CHENNAI METROPOLITAN DEVELOPMENT AUTHORITY
Thalamuthu Natarajan Building, No.1, Gandhi Irwin Road, Egmore,
Chennai - 600 008

(Development Charges Letter)

File No. : CMDA/PP/NHRB/S/0673/2020

Sub: CMDA-Area plans Unit - 'B' Channel (South) – Planning Permission Application for the proposed construction of Stilt floor + 3 floors (12.0 m height) Residential building with 12 dwelling units at Plot No.113 in Approved Layout P.P.D/L.O.No.81B/2002, Revreview Residency First Street, IAS/IPS Colony, Karapakkam, Chennai 600097 in S.No.435/3B2A2, 435/3B1B, 435/3A2A1B & 435/17B of Pallikaranai Village within the limit of Greater Chennai Corporation- Remittance of DC & Other charges – DC advice Sent - Reg

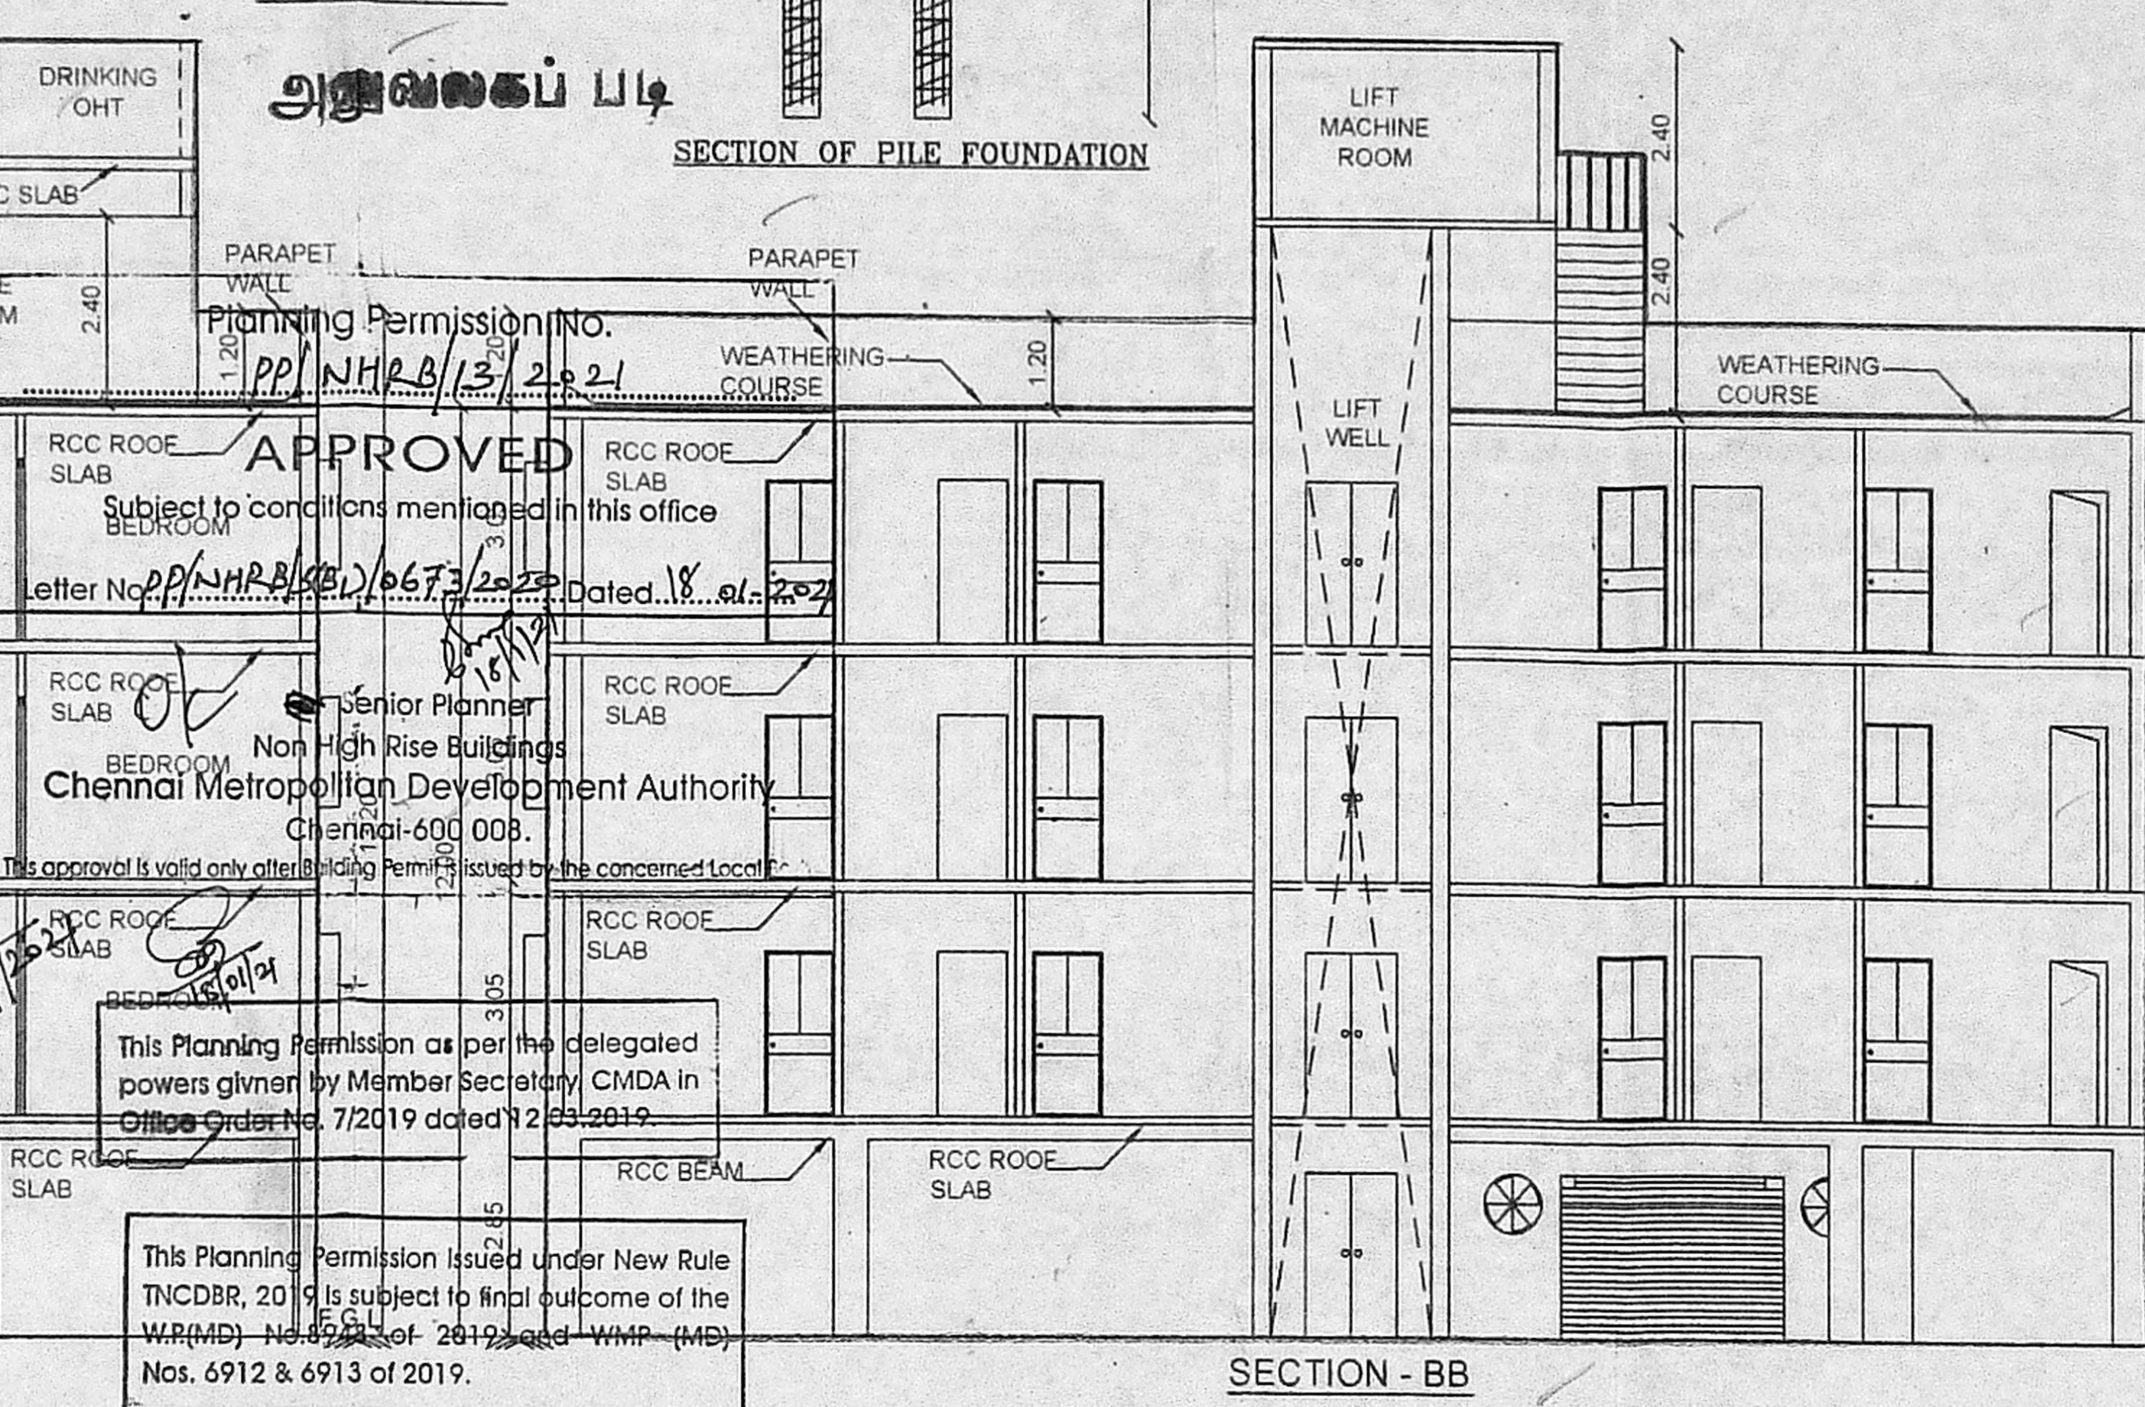
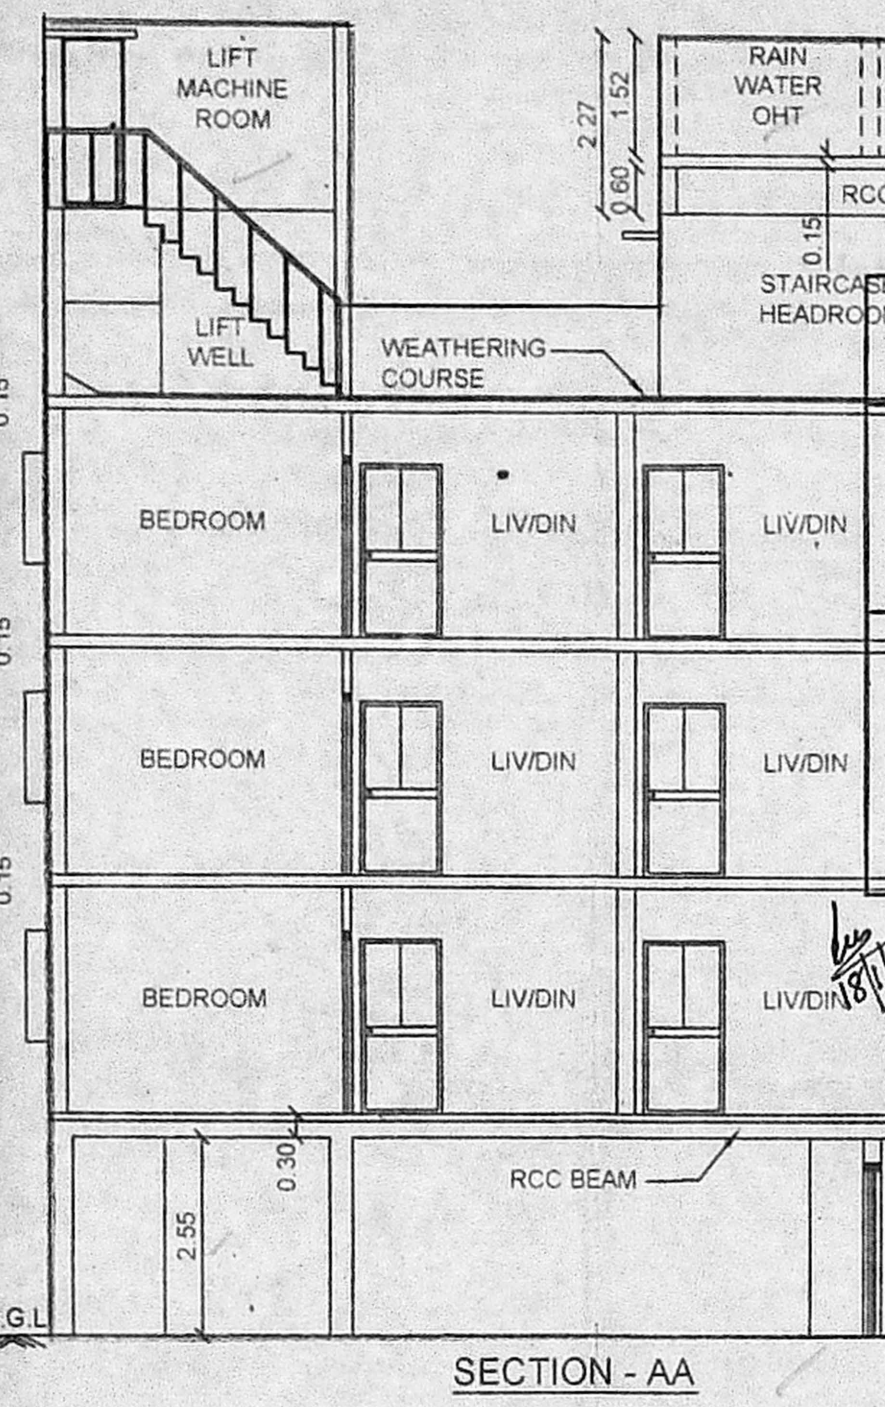
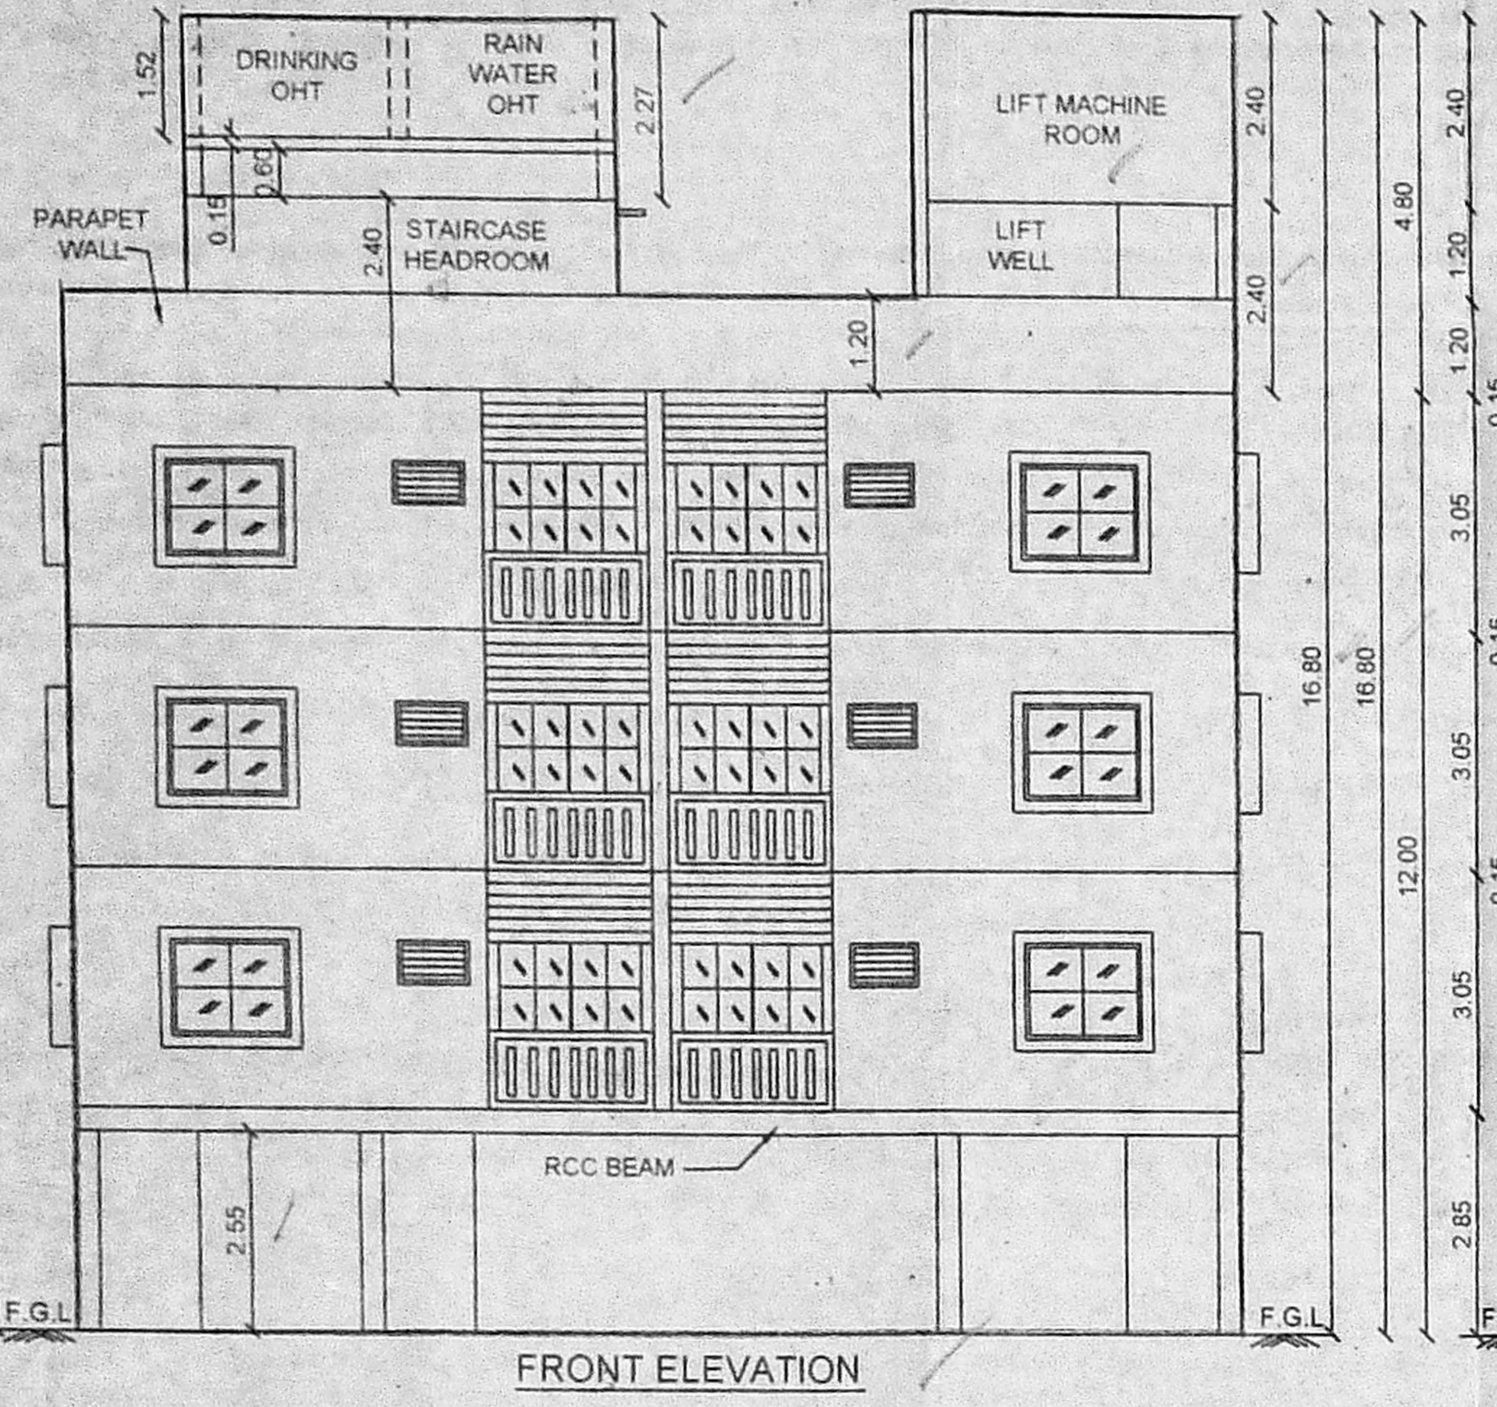
- FMB for the site under reference attested by Revenue officials not below the rank of Deputy Tahsildar to be furnished.
- Sullage sump to be deleted.
- Head room size to be reduced.
- Rain Water Harvesting details to be shown as per TNCDBR.
- Area statement needs correction.
- Section and Elevation needs correction.
